Letter No. B2/21471/93

Sub: MDA - APU - Construction of
Residential/~~Commercial Building~~ **XXXXXX XXXXXXXXXXXXXXXX Group Housing**
at S.No. **77/9, 78/4, 83/1 XXXXXXXX 83/2, 84/1** **Development**
84/2 & 85/1 in
Remittance of D.C., S.C., S.D., **Noombal**
XXXXXX **Village.**
O.S.R., S.D. for upflow filter -

The Planning Permission Application received in the reference cited for the ~~additional~~ construction of Residential ~~Plots/Commercial Building~~ at the above site under reference was examined and considered to process further ~~subject to Metro Water Clearance and~~ subject to the following conditions stipulated by virtue of provisions available under DCR 2(b)ii:-

SITE PLAN

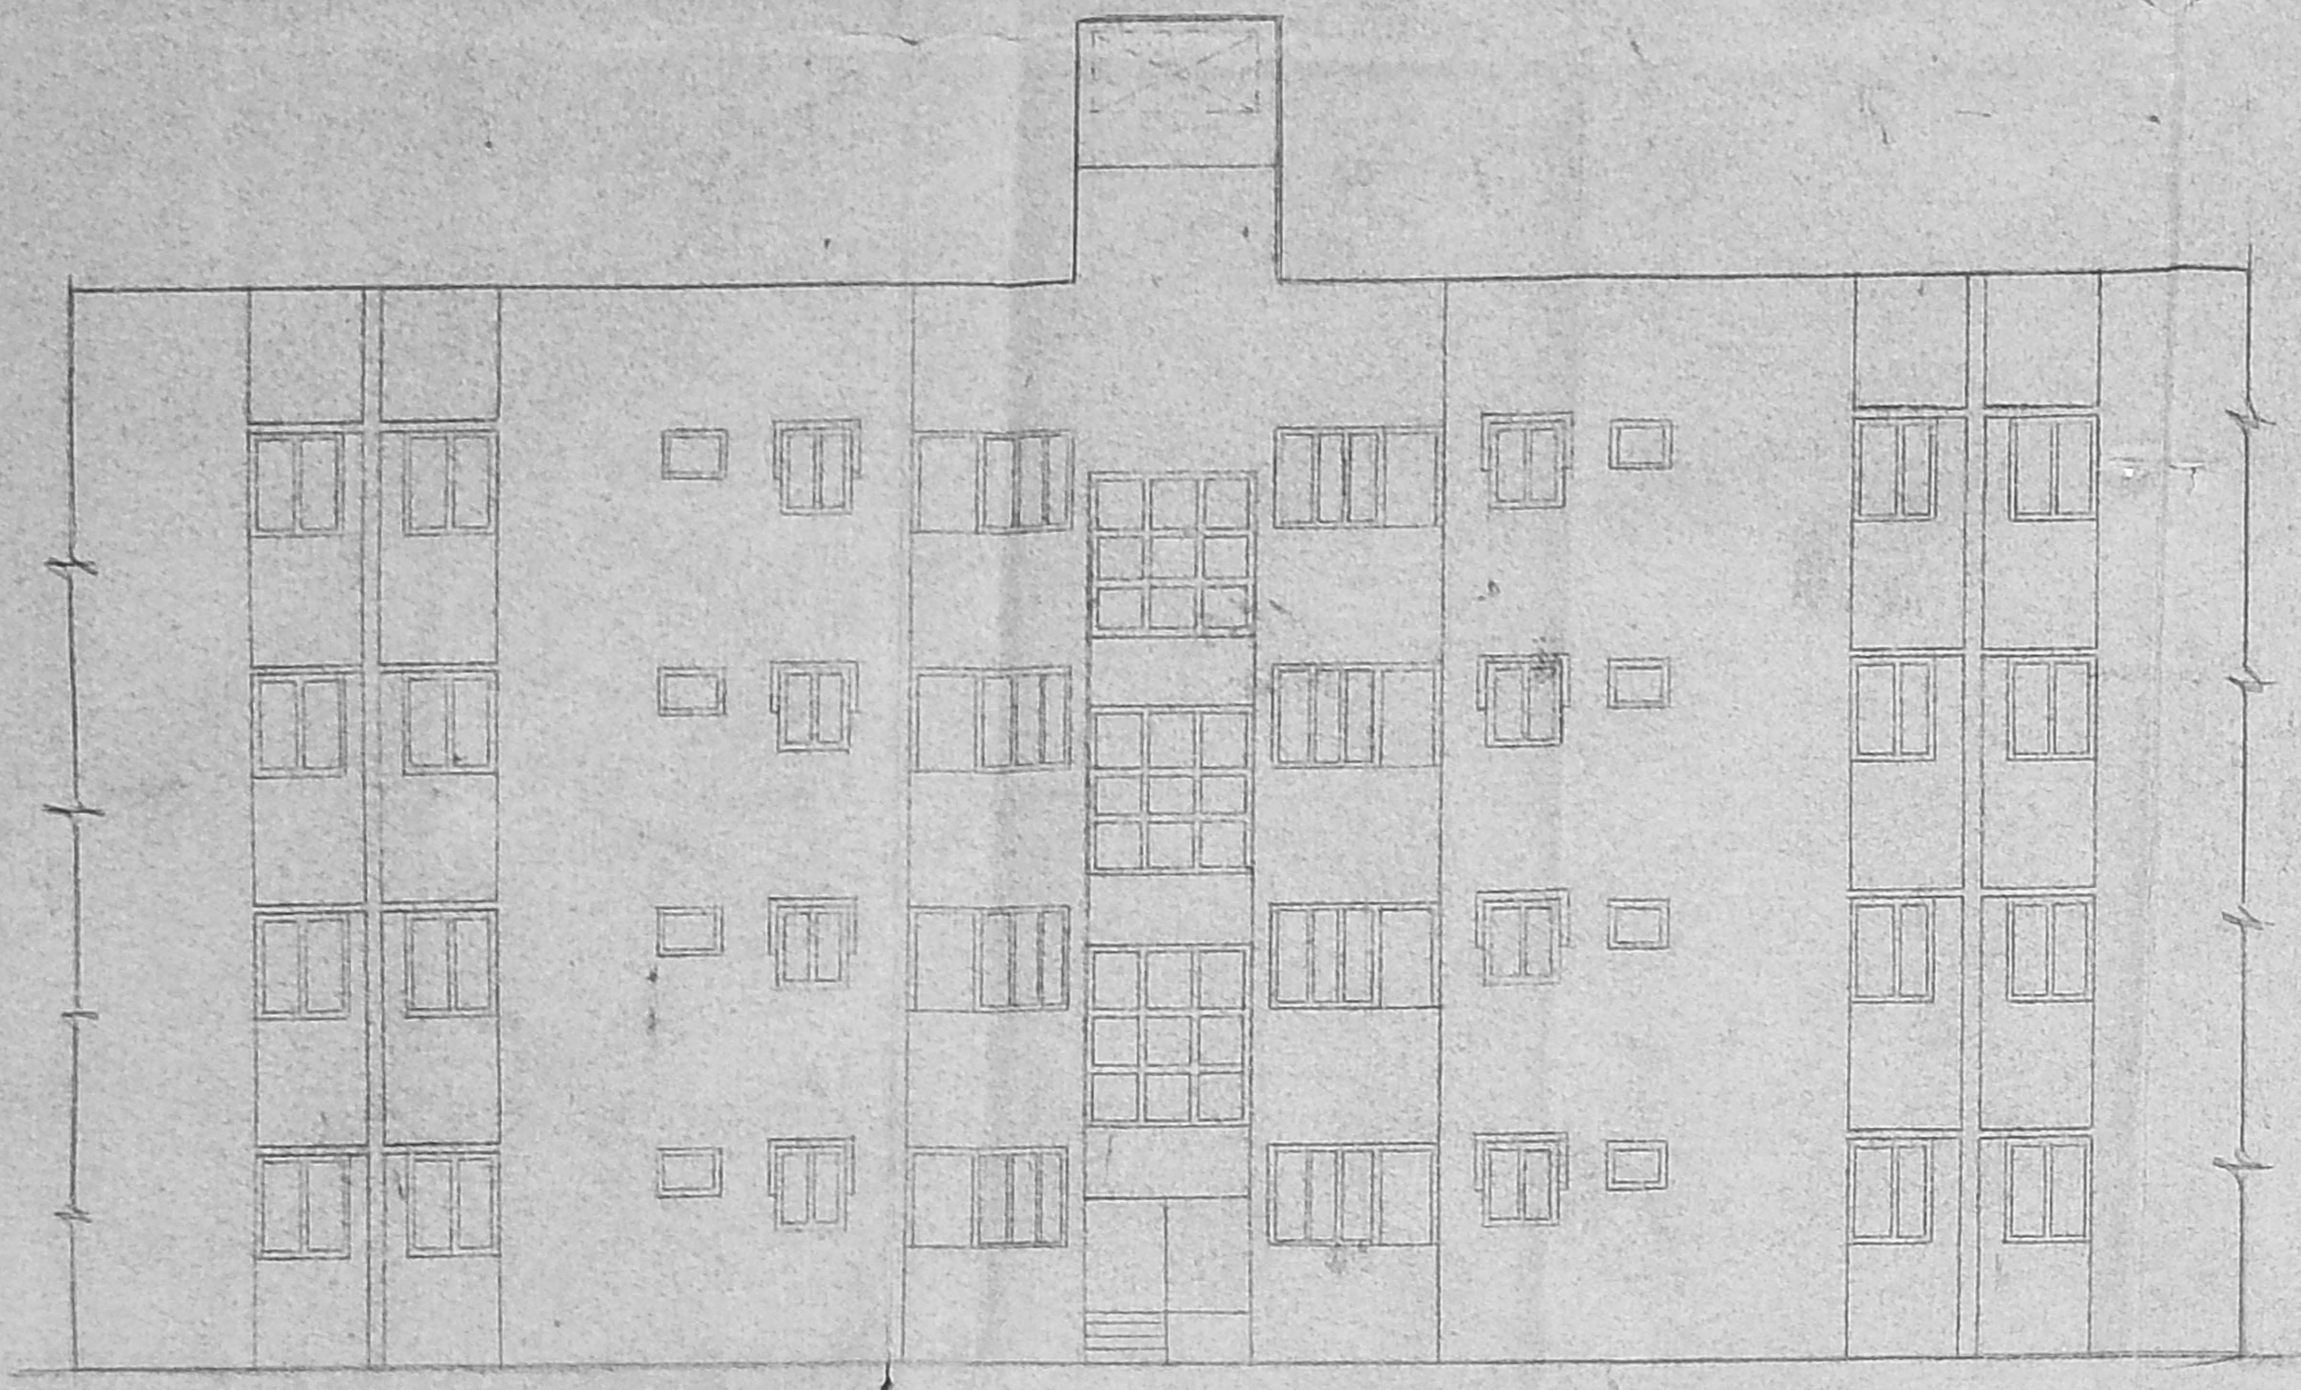
- xii. Shifting of HT & LT lines passing through the site.
 - xiii. Handing over of OSR area & 10 m. wide road to the Local body through registered gift deed (for which under reference is sent separately).

PRIMARY SCHOOL

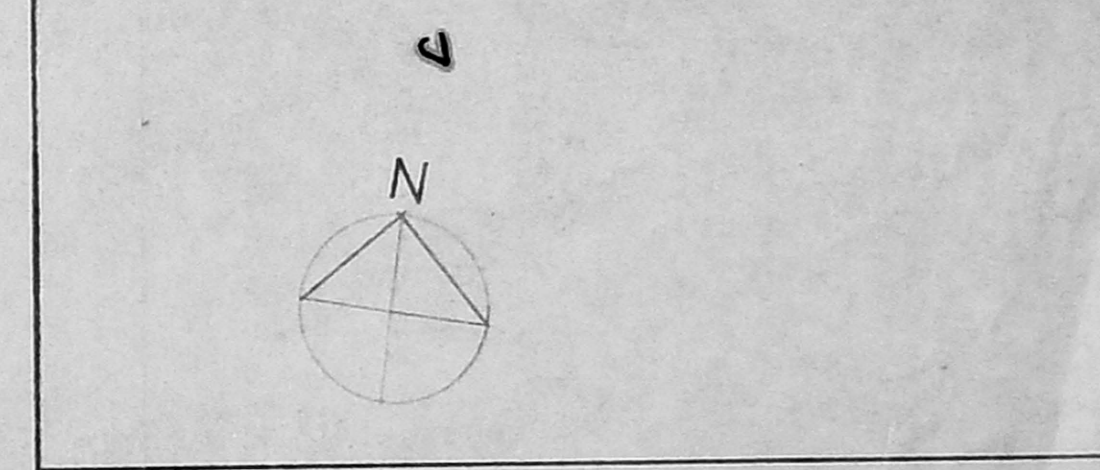
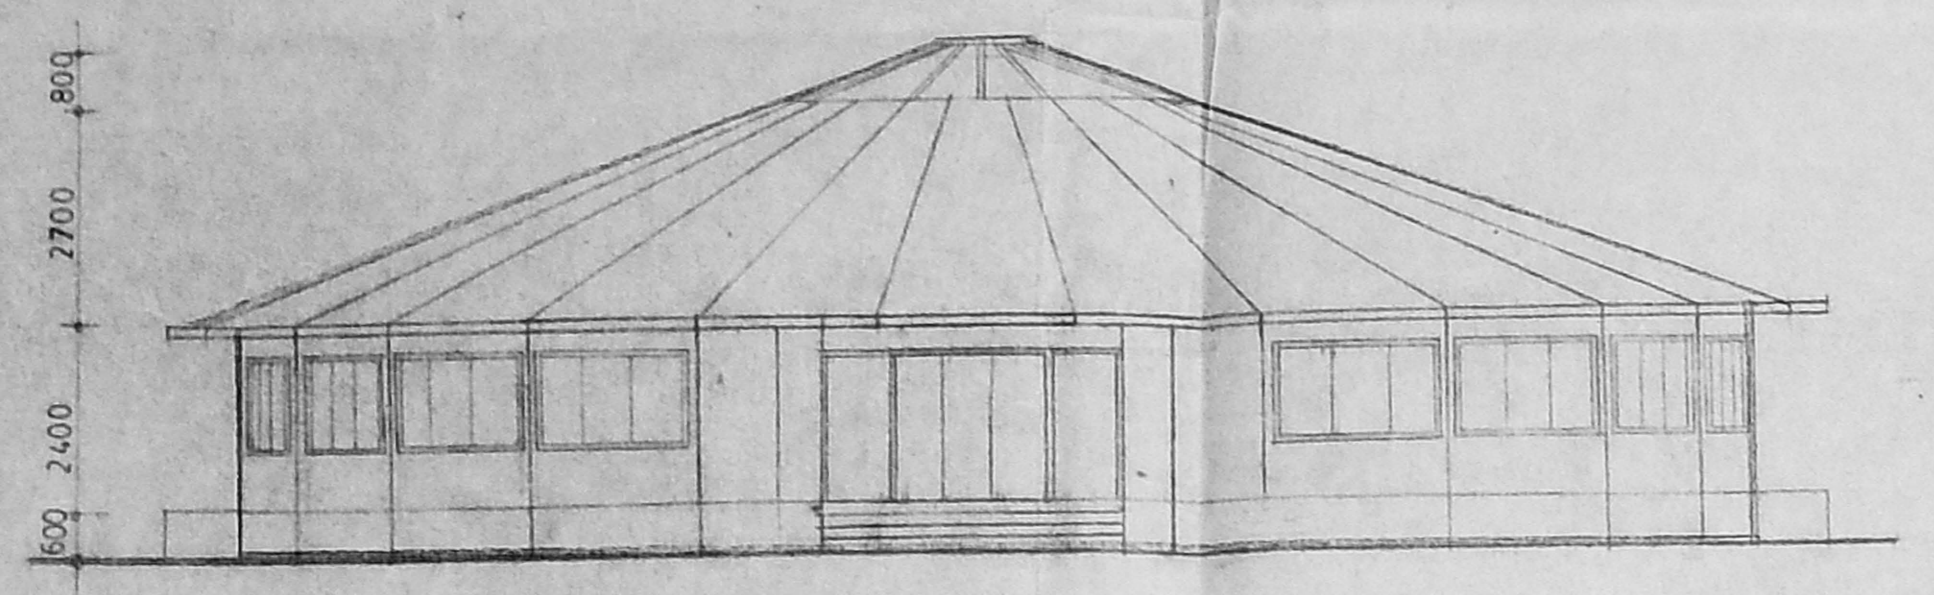
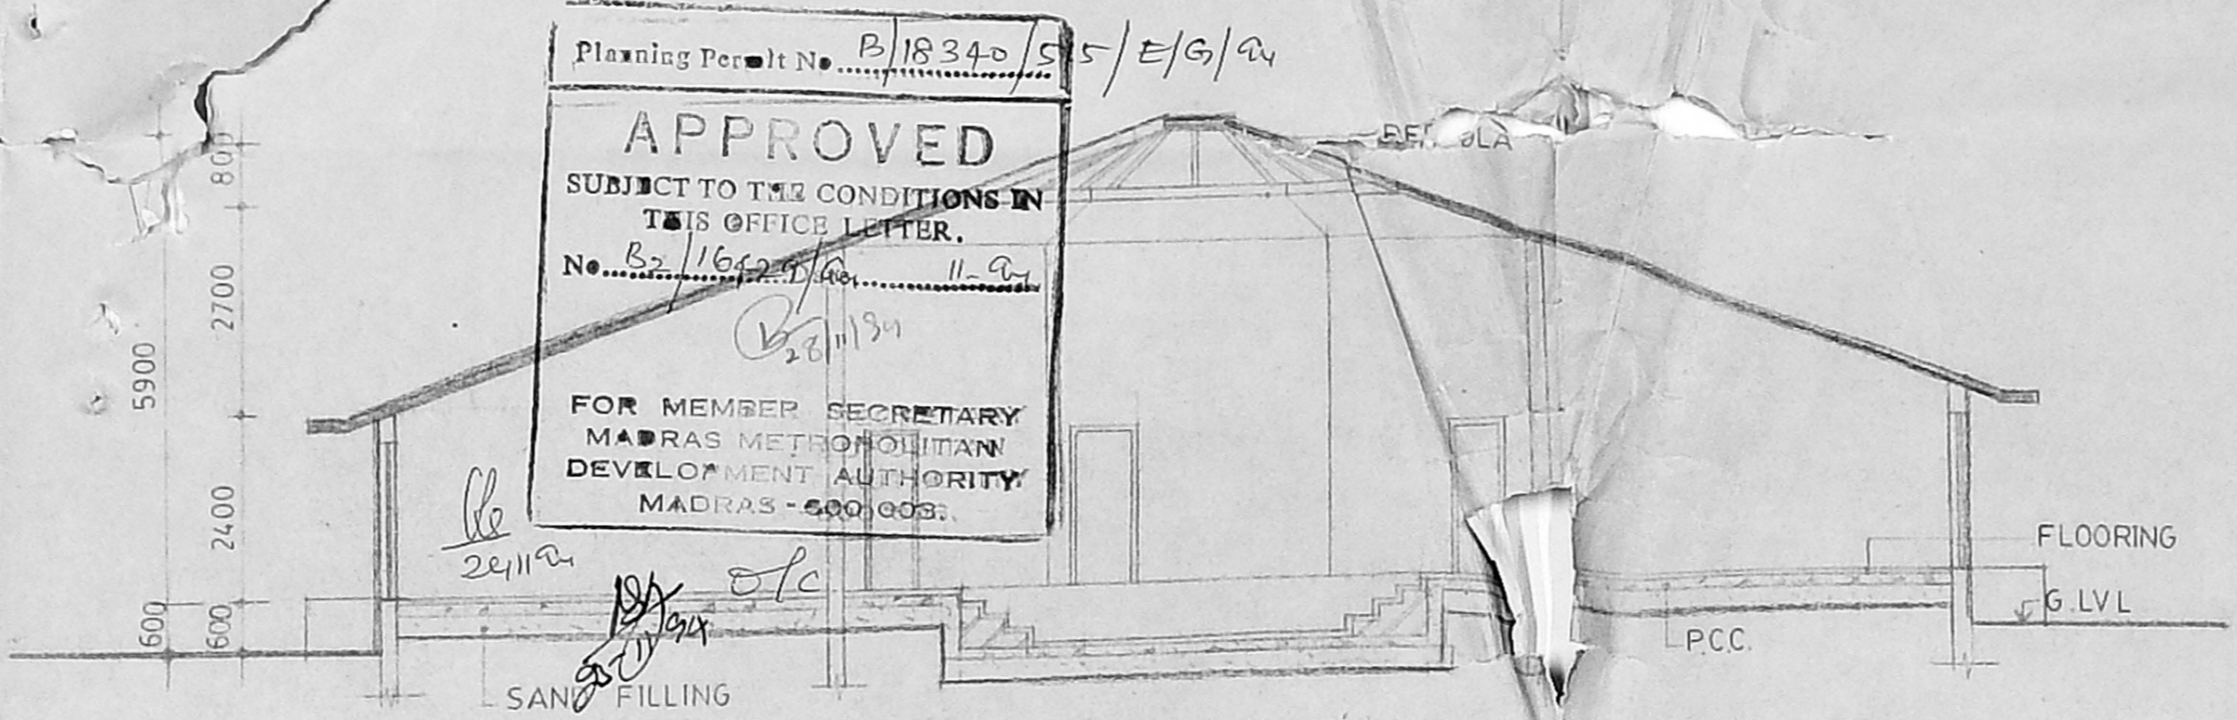
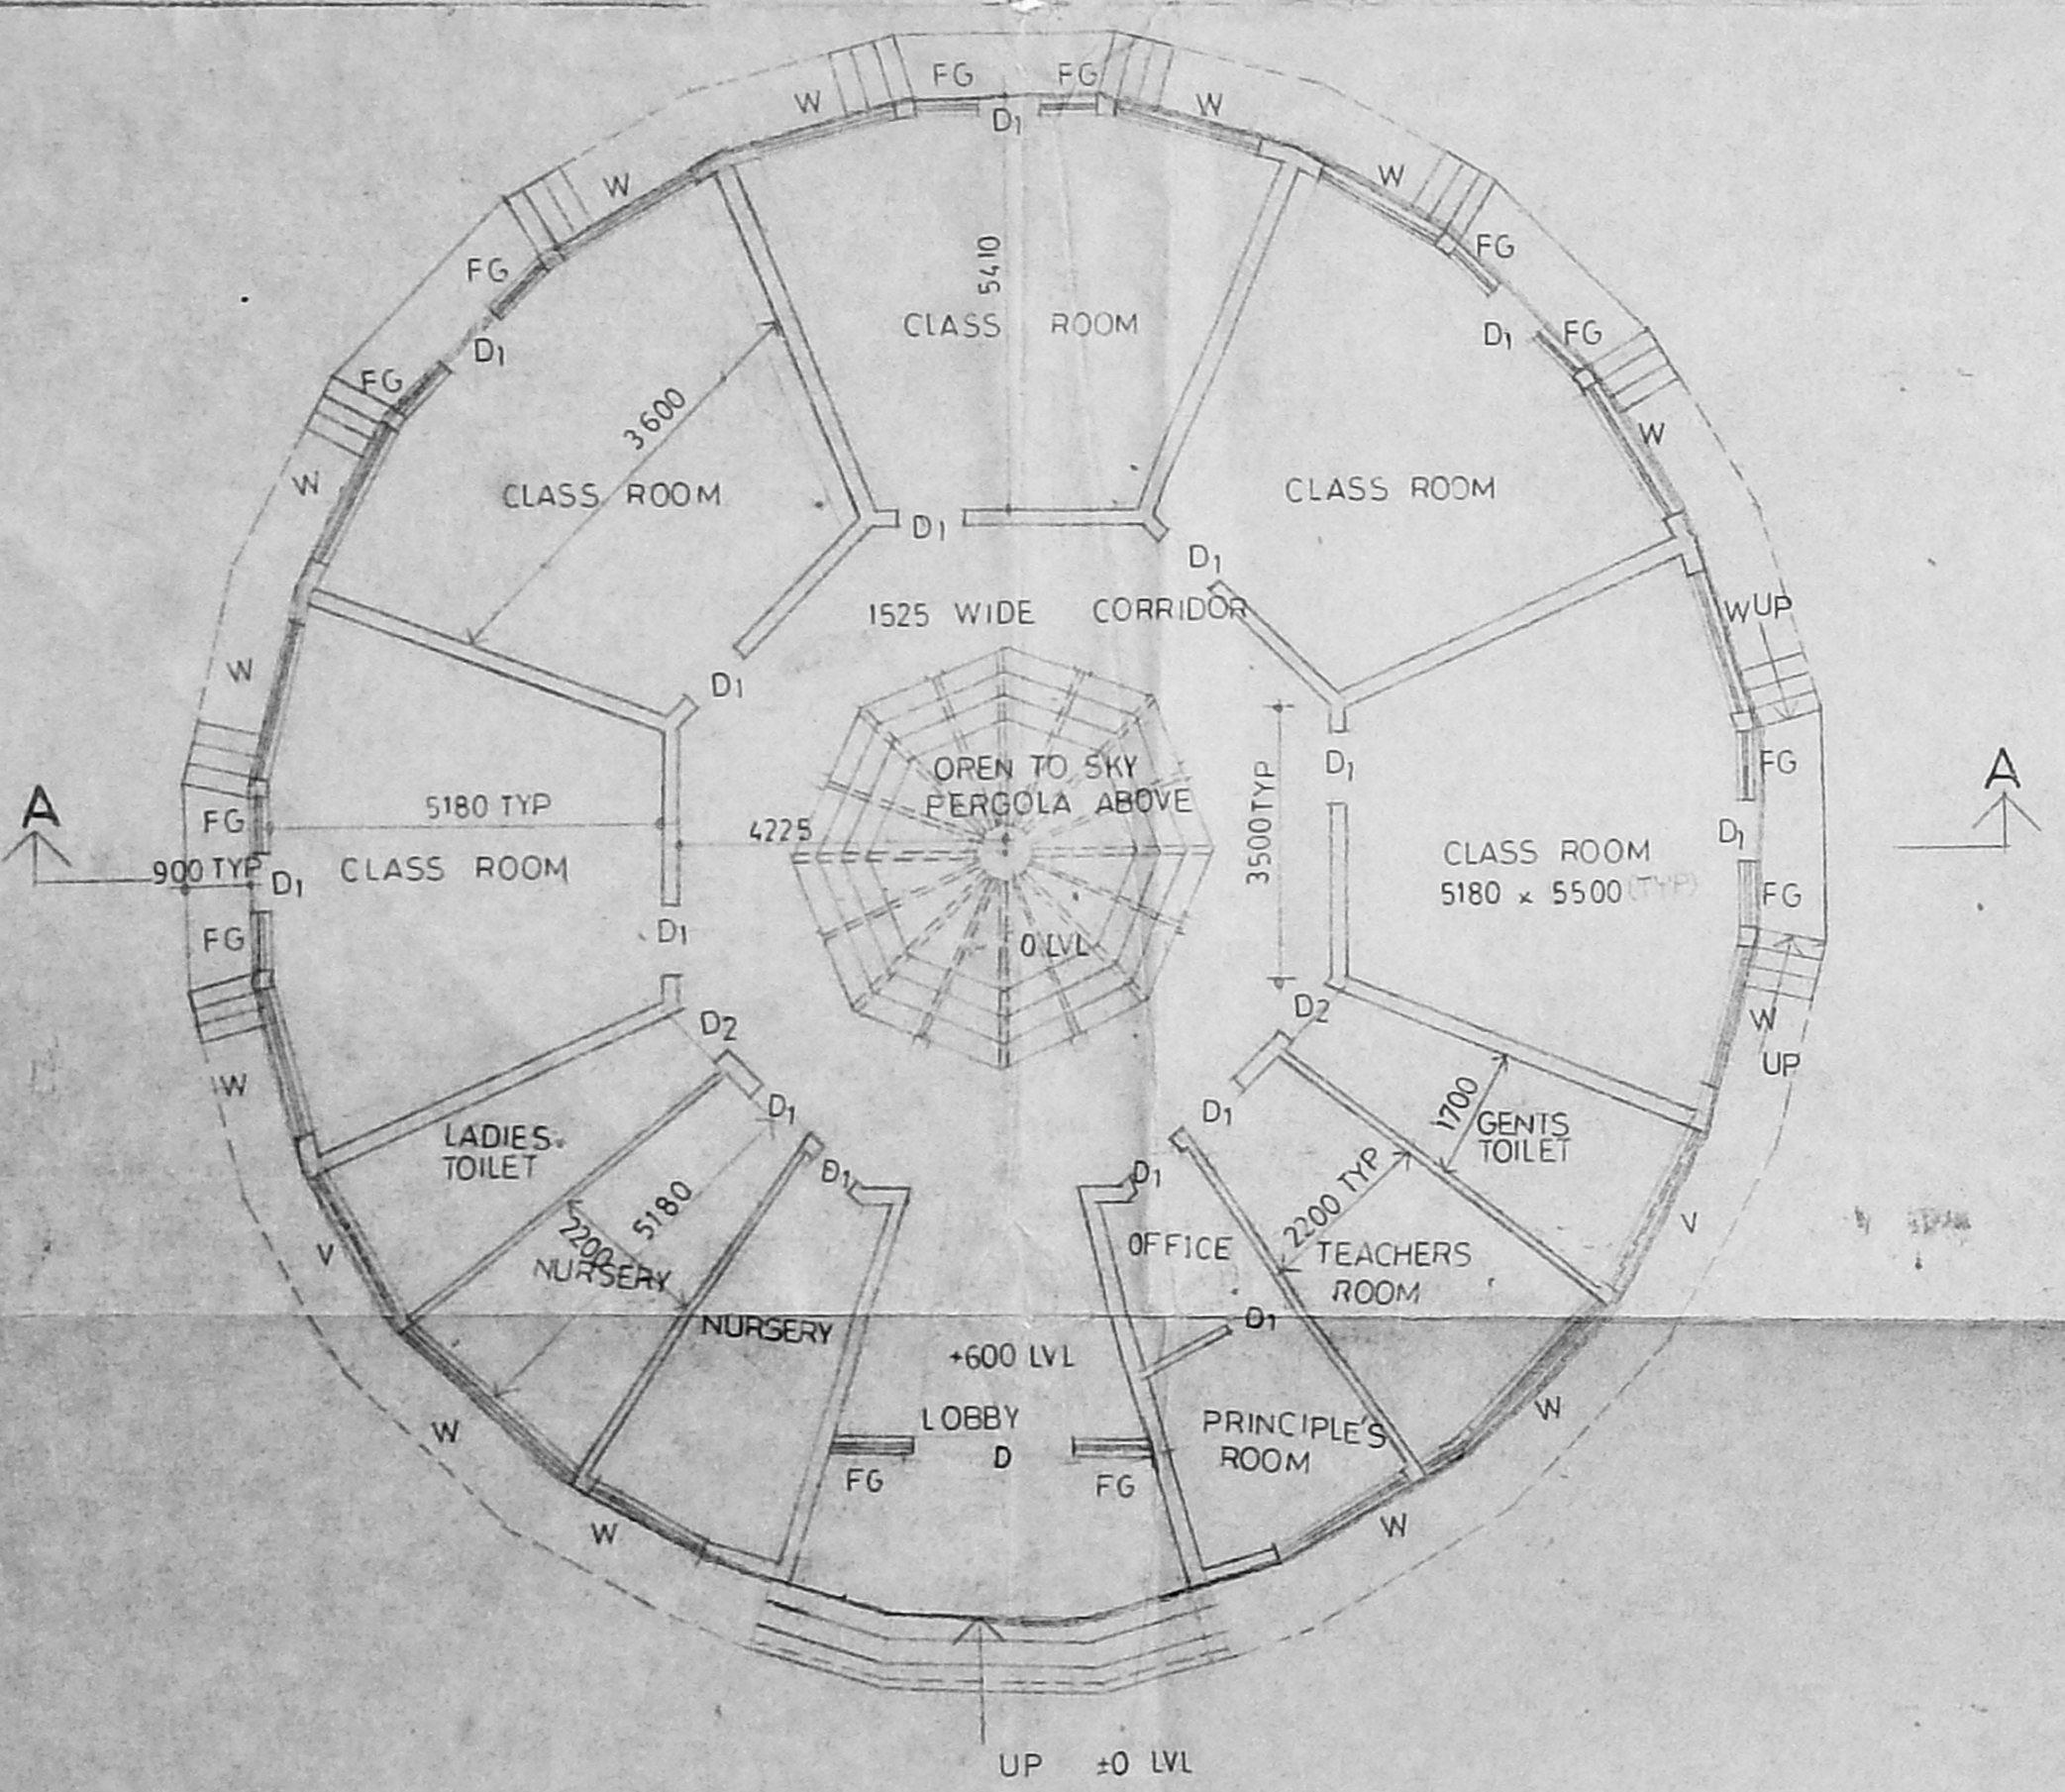
- c) Furnish the information and letter of undertaking as required under 2(a) and 2(b) above.
- d) Give an undertaking in Rs. 10/- stamp paper attested by the Notary Public (A copy of the Format is enclosed herewith).
- e) A copy of the format enclosed for display of particulars for ~~SS~~ Special Buildings and the display with details at the site is compulsory.
- f) For the payments received after one month, interest shall be collected at the rate of 12% per annum (i.e. 1% per month) for the every completed month from the date of issue of this advice.
- g) You are requested to furnish revised plans providing a primary school and showing its location and detailed plans for the same.4.
